Re: Proposed Section 96 (1A) Modification to SSD 5237-2012 Wagga Wagga Base Hospital Phases 2 and 3

In November 2013, the above application was approved for the Wagga Wagga Health Service Redevelopment (WWHS). SSD 5237 dealt with Phases 2 and 3 of the hospital redevelopment and included:

The purpose of this letter is to outline the amendments proposed and to assess the impacts of these changes on the environment.

DRAWING TITLE:
SPARKLE GARDEN HARDWORKS AND PLANTING PLAN

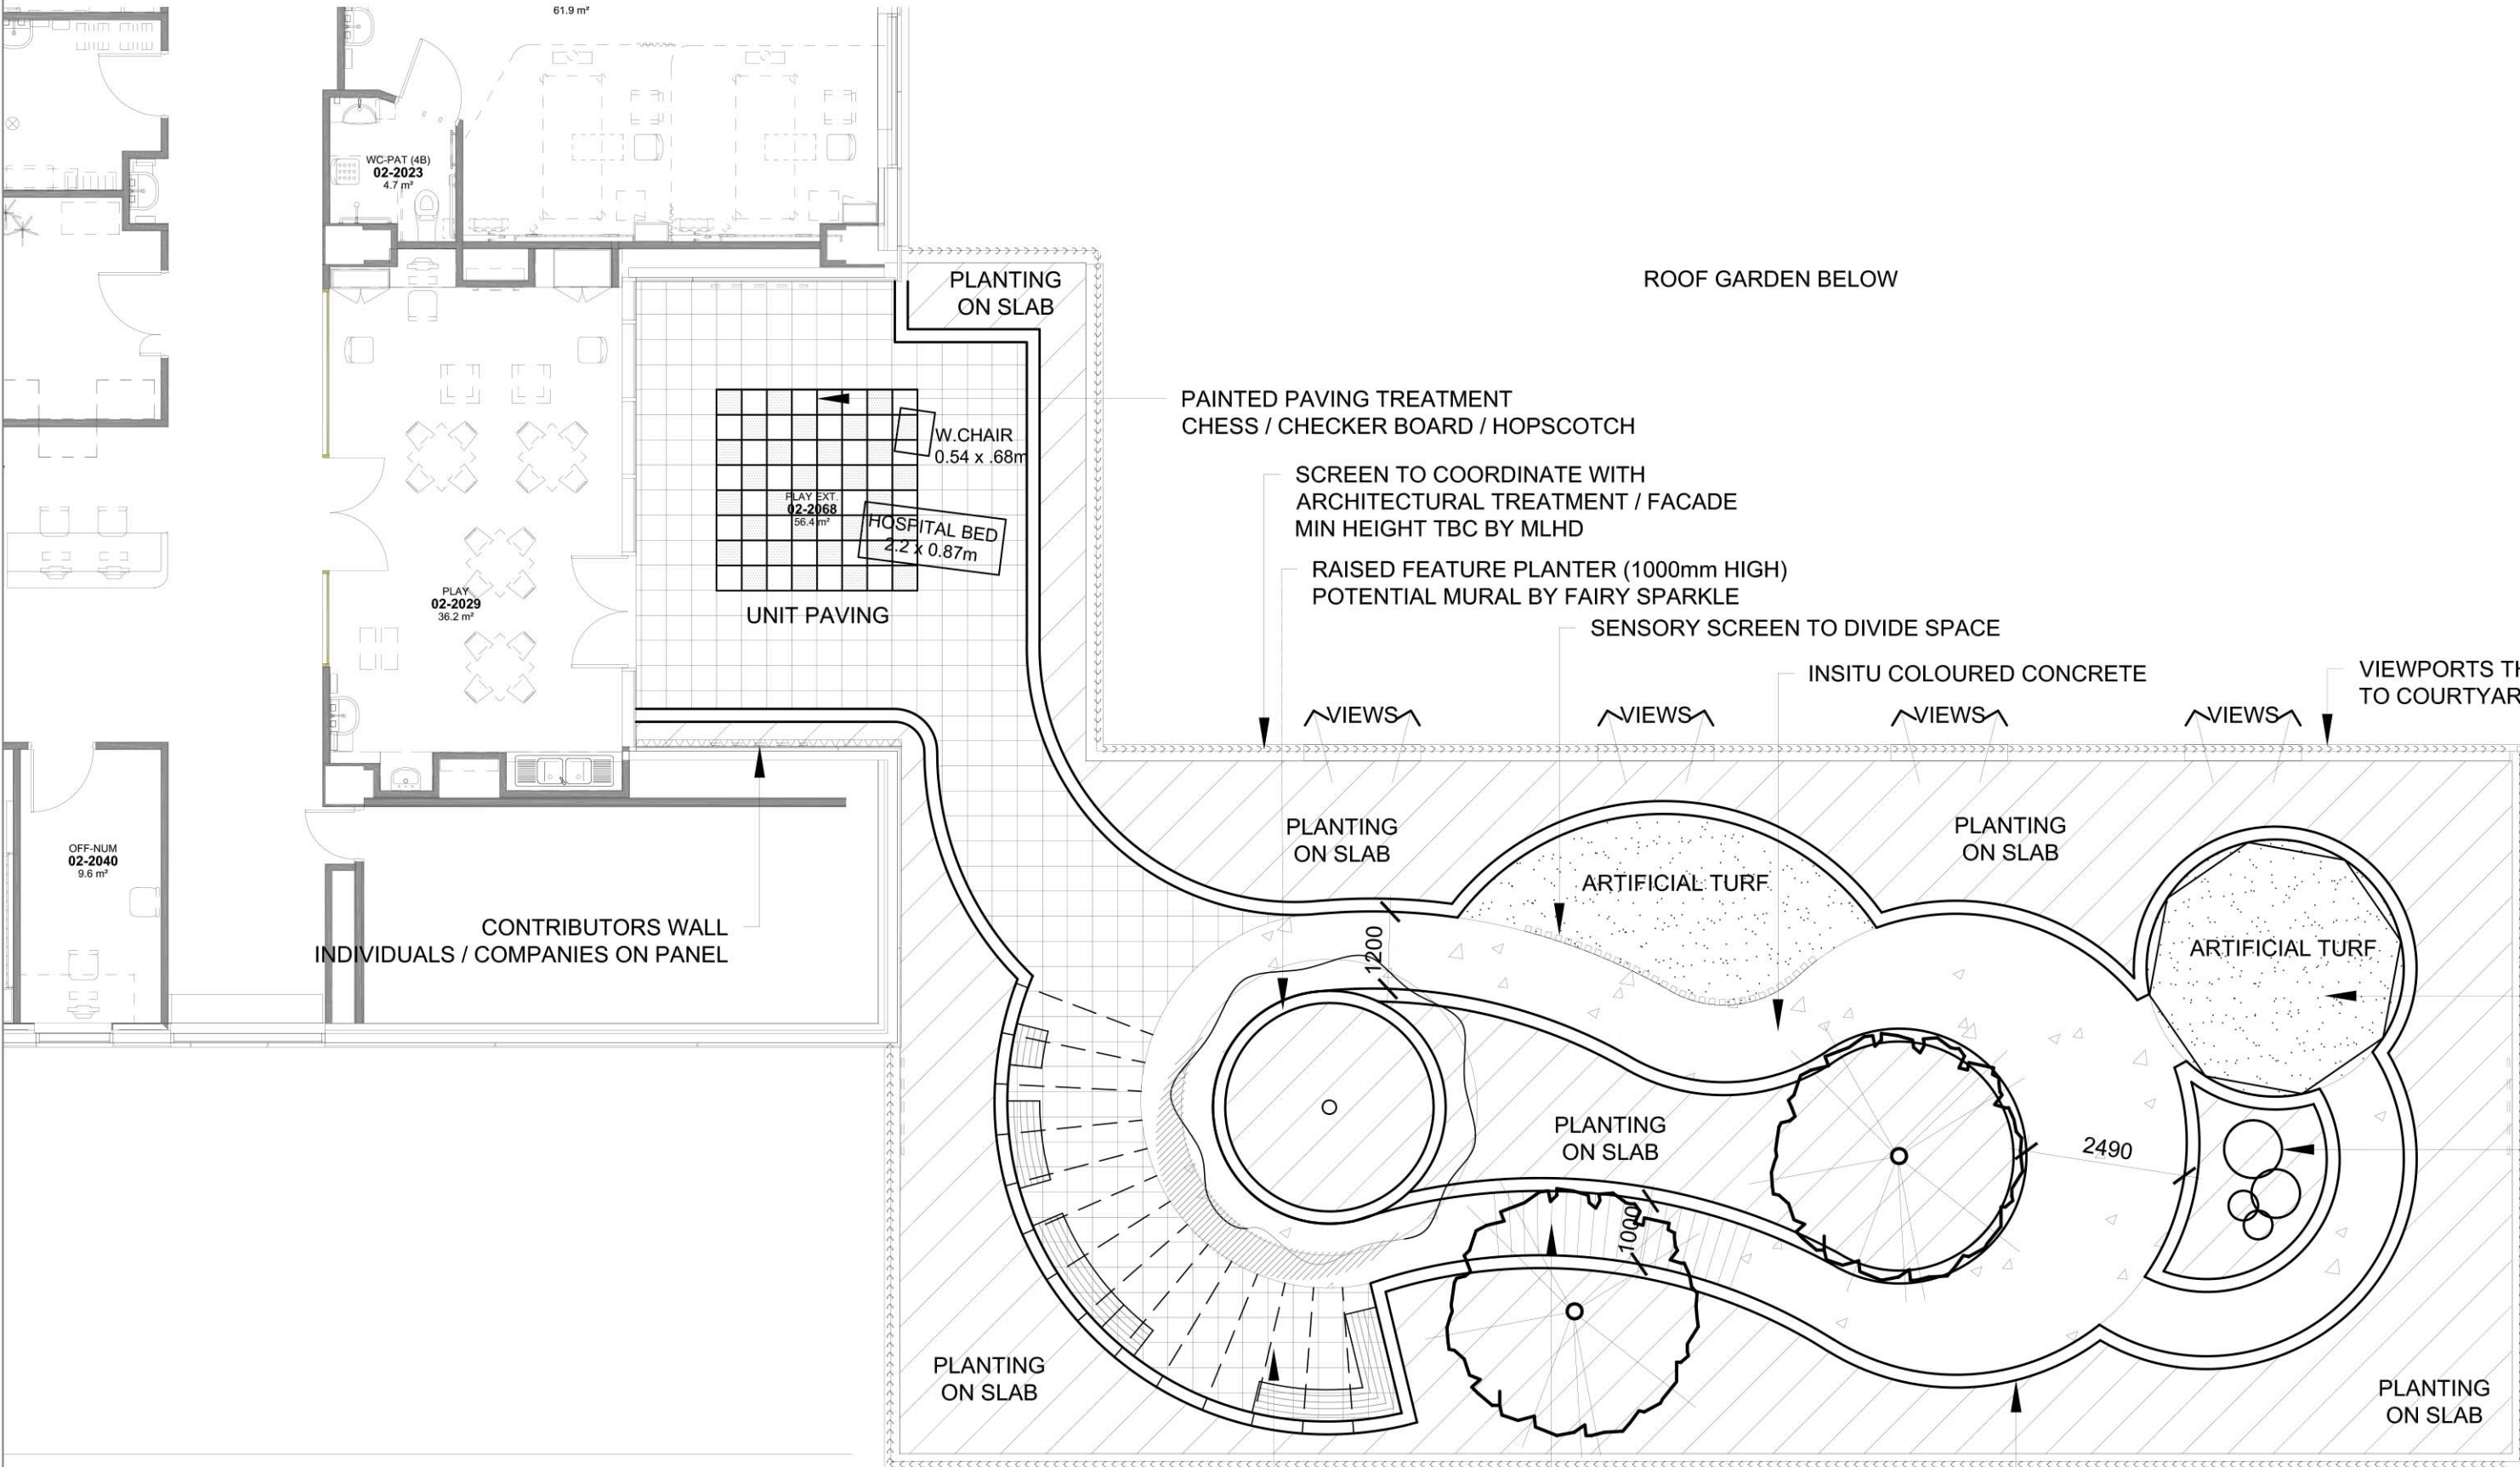
The landscape design has been rationalised in order to reduce ongoing maintenance costs as well as providing a species selection that will minimise irrigation usage. Hard landscape areas, including pavement design and street furniture have been redesigned to meet guidelines for health facility setting. These changes are considered minimal and are consistent with the most recent works that have been completed for the adjoining health facility.

NOTE: NEW HOSPITAL TOWER SHADOWS SHOWN IN BLUE. EXISTING CONDITION SHADOWS ILLUSTRATED IN GREY.

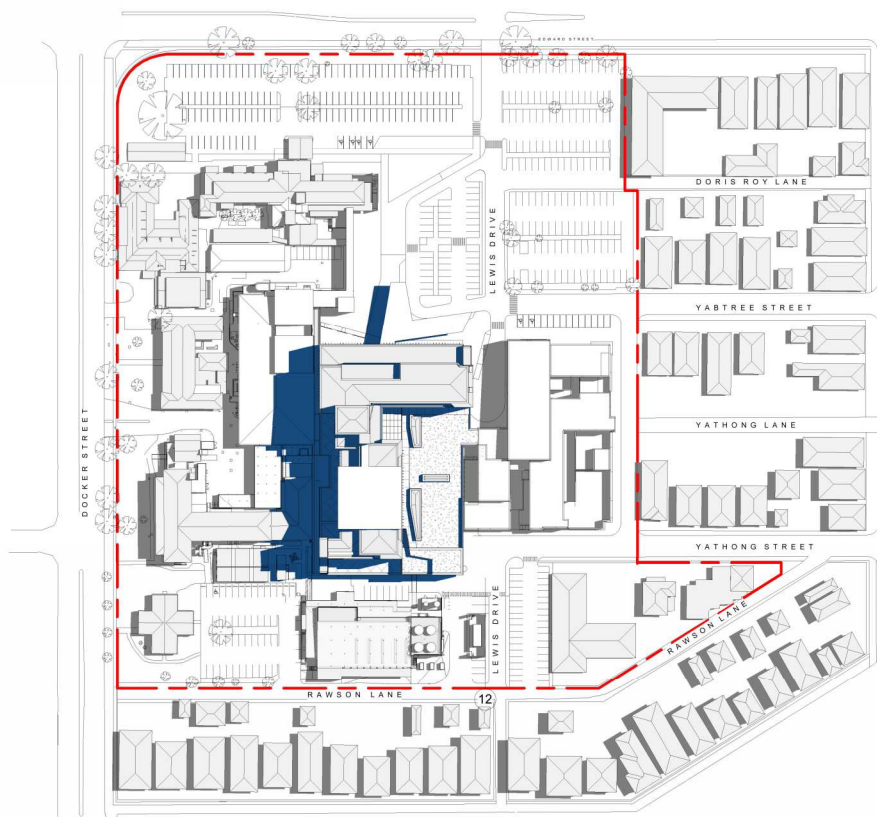
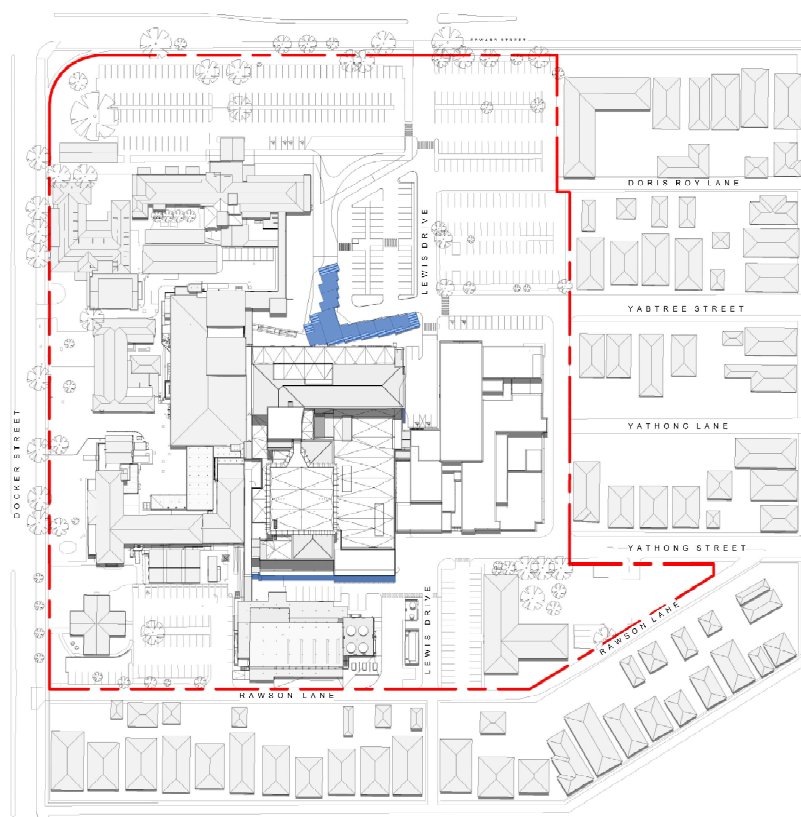
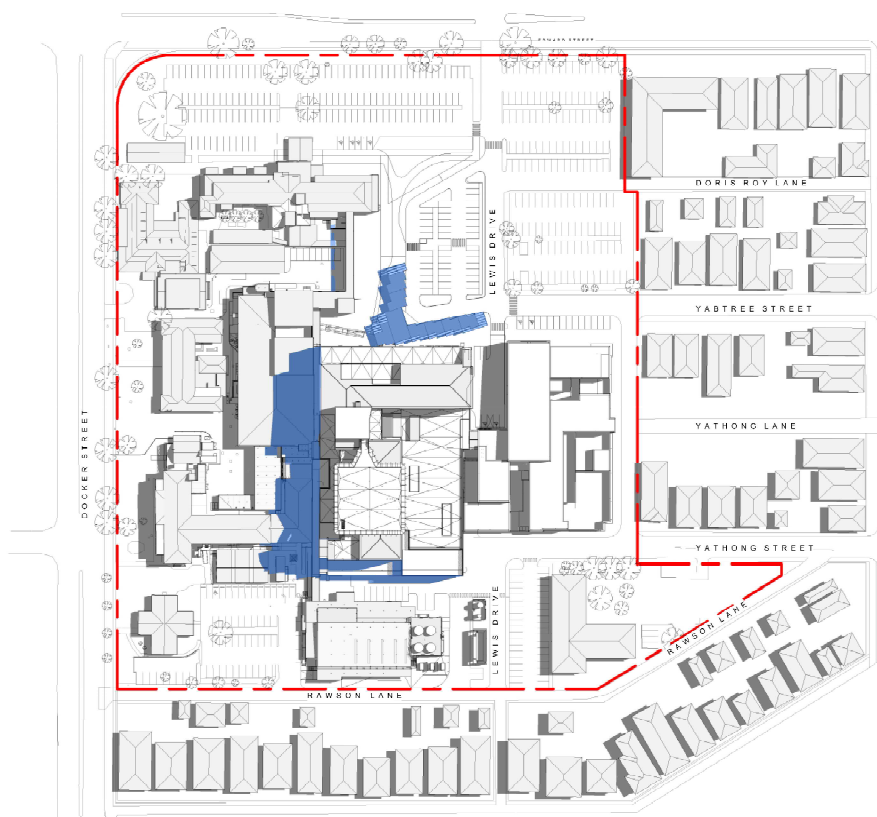
The building floor plate has been raised by 300mm from Level 2 to maximise the freeboard interface with the Level 2 podium green roof. All floors above that have been raised as a consequence increasing the maximum height of the building by 300mm to RL 220855. An increase of 300mm to the overall height of the building is not considered to have an impact. Revised shadow diagrams have been prepared and are attached that indicate that the shadow impacts of this amendment are negligible.

1 ACUTE HOSPITAL PRECINCT NORTH ELEVATION
1:200

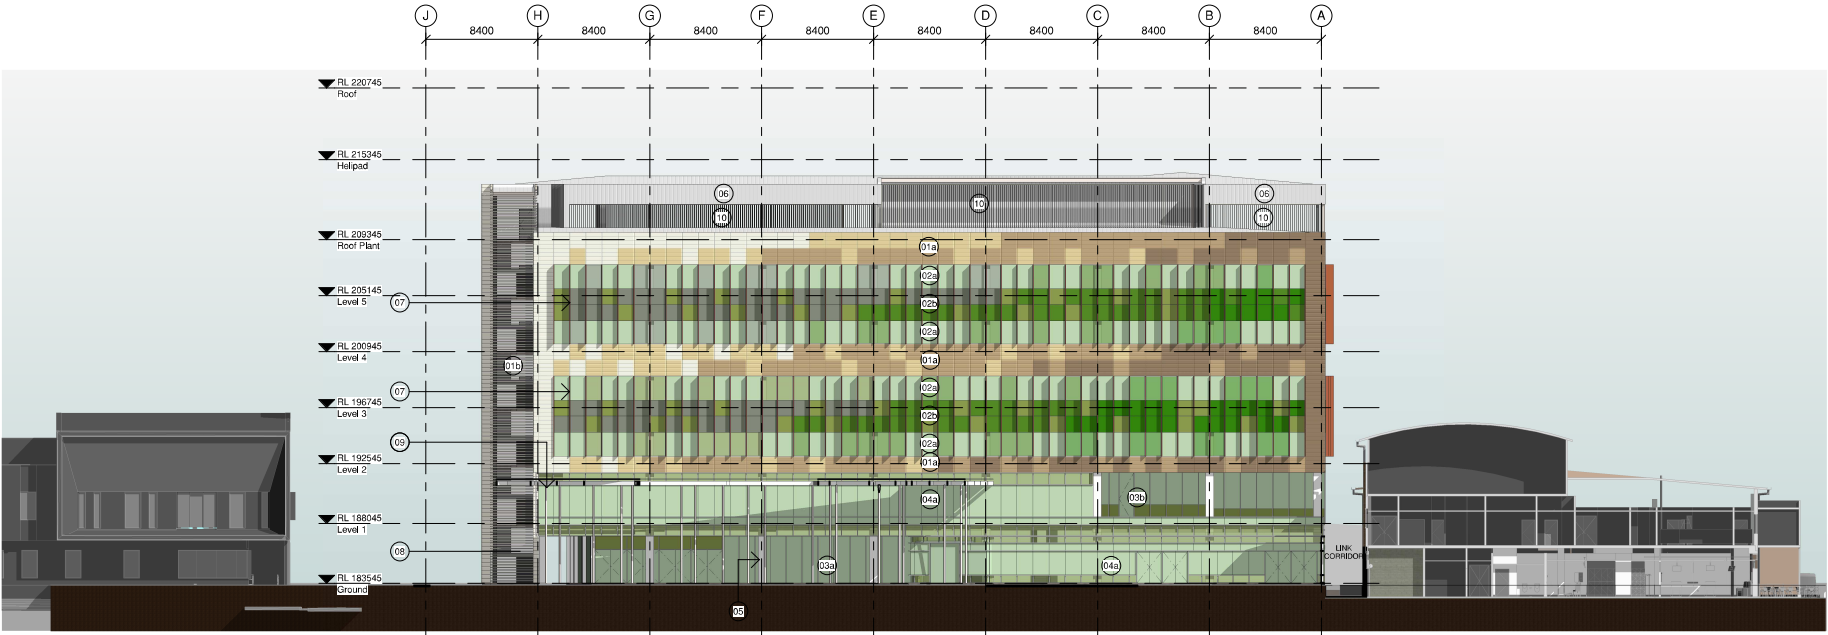
The material Terracade (ceramic tile cladding system) & anodised aluminium façade cladding has been replaced with an aluminium composite panel (ACP) system. The vertical sun shade fins have been deleted. The façade panel break has altered to suit the new cladding material. There is no change in the overall colour scheme. The details of these changes are shown on the attached drawings and comparison sheets (Attachment A).

This change involves sections of the façade at level 6 that had been set back in the approved plans now being aligned with façade building envelope below. The riser located on the north side of the lift shaft has been truncated to terminate at the L.6 plant room roof and the plant room area has been reduced and the southern screen deleted.
